Planning Application Ref: **AW/321/18/T**

Location: **106 Barrack Lane, Aldwick PO21 4EA**

Description of works: **Reduce by 1m to old cuts 2No. oak trees and reduce by 2m to 1No. maple tree.**

106 Barrack Lane

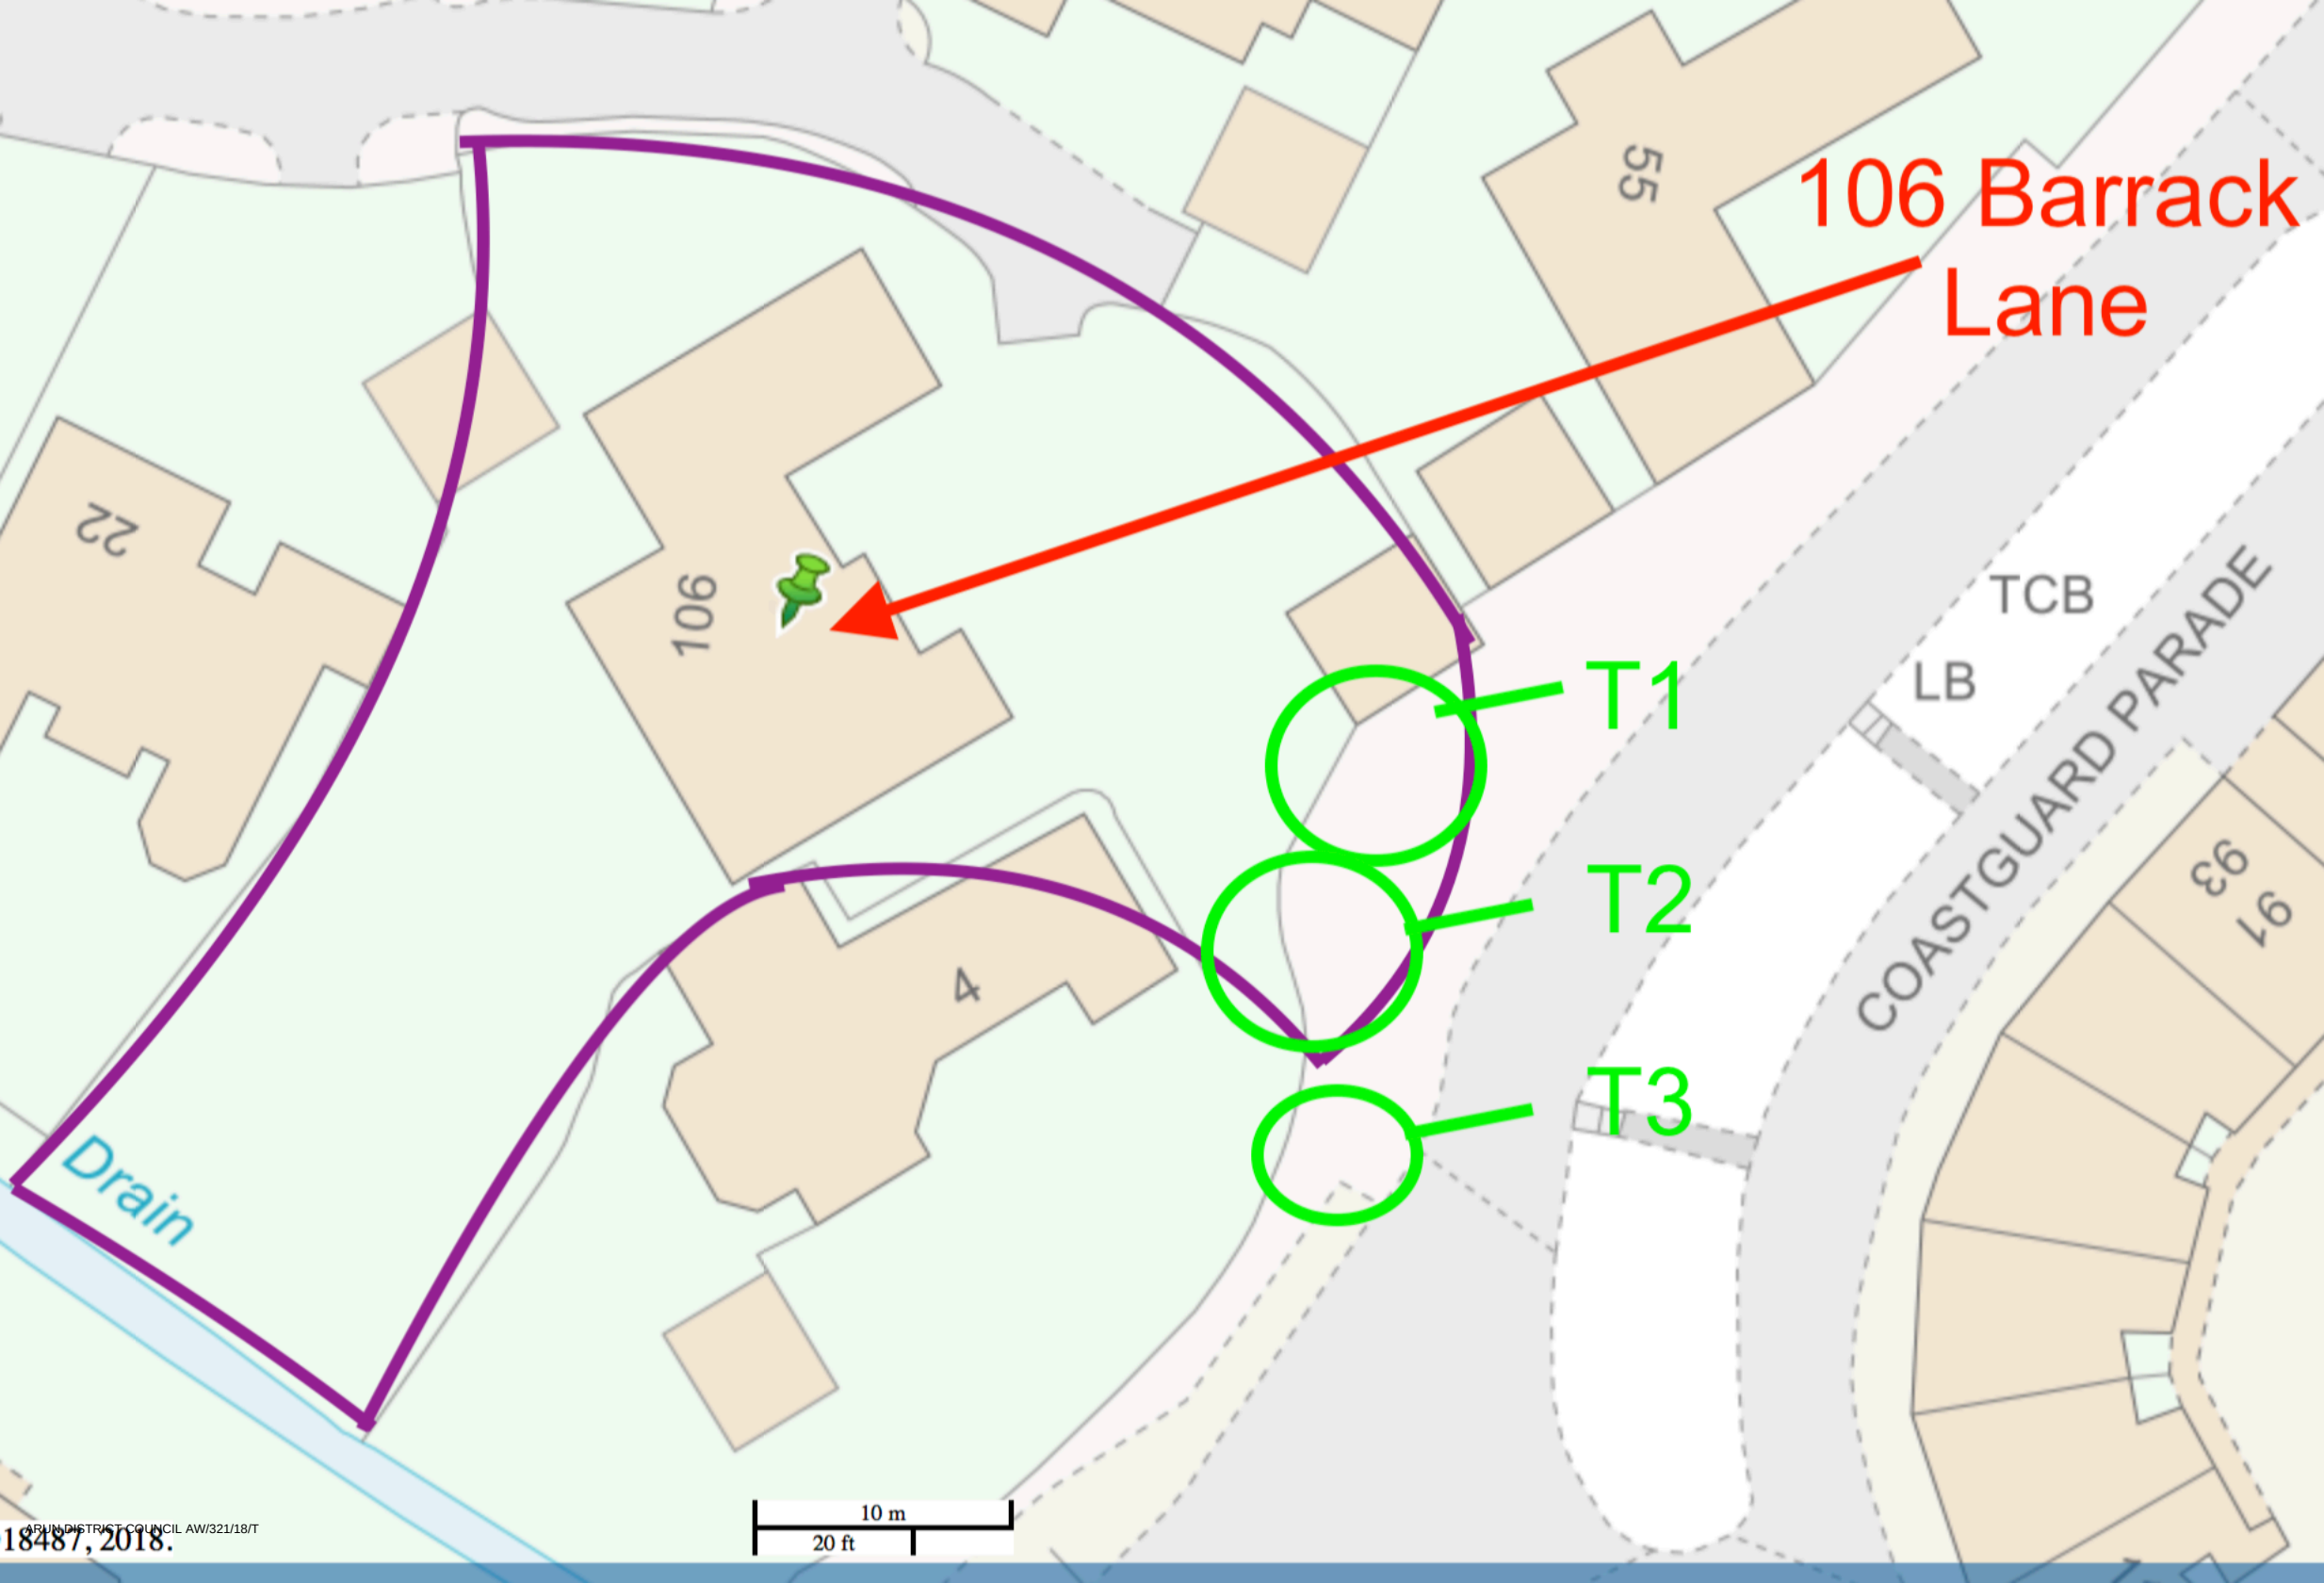
- Outwardly and from a distance it appears to be in a fine physiological state but with heavily modified or suppressed form.
- They grow to the front of the property effectively on roadside verge and are prominent. They are highly visible from the public highway (road, footway and commercial premises).
- T1 is a low quality specimen, having been suppressed by companion trees.
- T2 and T3 have been the subject of past crown modifications resulting in relatively small and compact limb/branch framework. This work was most recently undertaken late 2015/early 2016.

- T1 - Field maple is not the subject of any Order (TPO) nor does it reside within Conservation Area, therefore the consent of the local planning authority is not required before undertaking any work to this tree.
- T2 and T3 - Cyclical crown reduction work throughout the remaining life-span of these trees will be necessary to achieve a degree of structural integrity appropriate for their location.
- T2 and T3 - There is insufficient extension of new growth (1-1.5m) since the last major pruning operation (c2015/16); so that repeat crown reduction at this time (or within the next 2years) would be too early in the management cycle and likely have a negative effect on their long-term vitality.

- I recommend **REFUSAL** for this application.
